OUT17/44462

**Newcastle Gas Storage Facility (MP 10_0133 MOD 3)
Comment on the Environmental Assessment (EA)**

Figure 4: Proposed Modification Layout

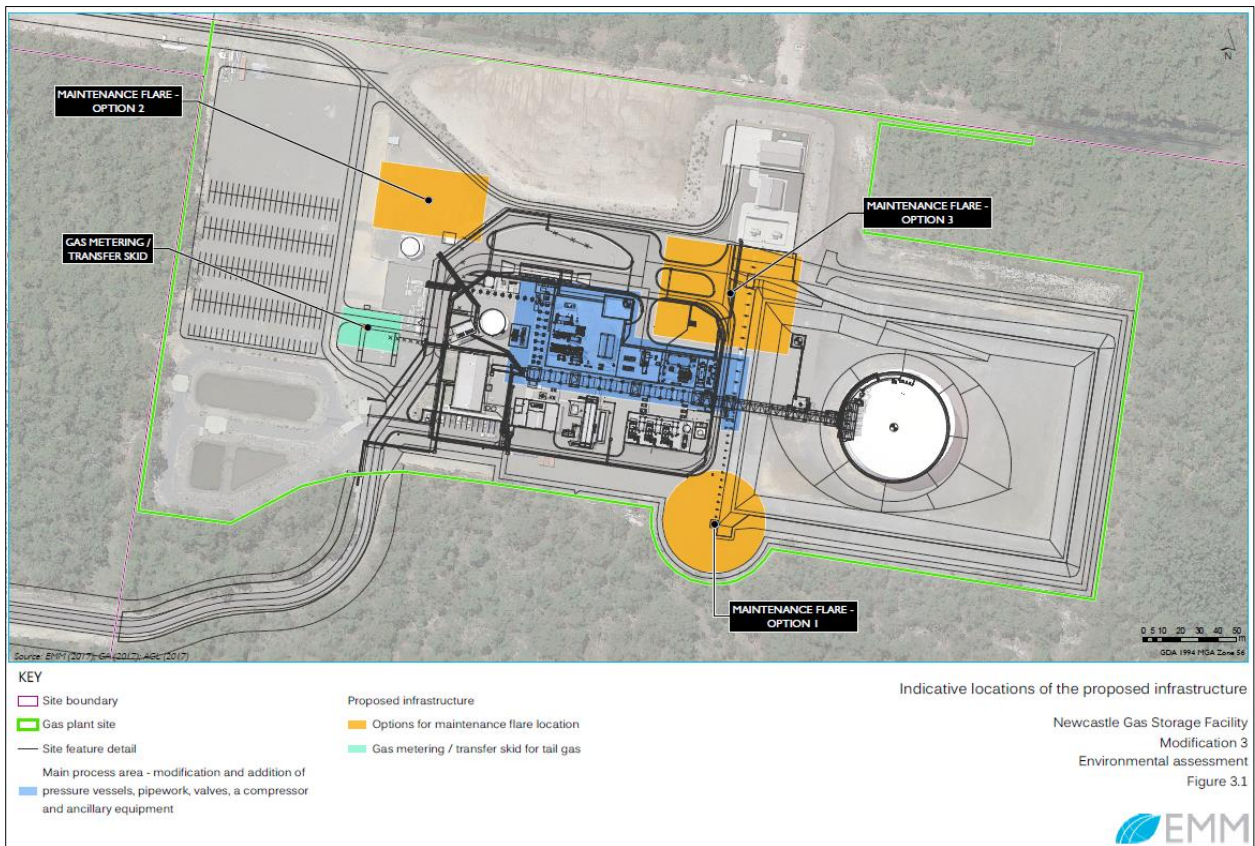
- The proponent should clarify whether the minimal earthworks required for construction of the maintenance flare and transfer skid will intercept any groundwater.
- Should any works intercept, or be likely to intercept, groundwater the proponent should be required to consult with Crown lands and Water (water.referrals@dpi.nsw.gov) on monitoring and licensing requirements.
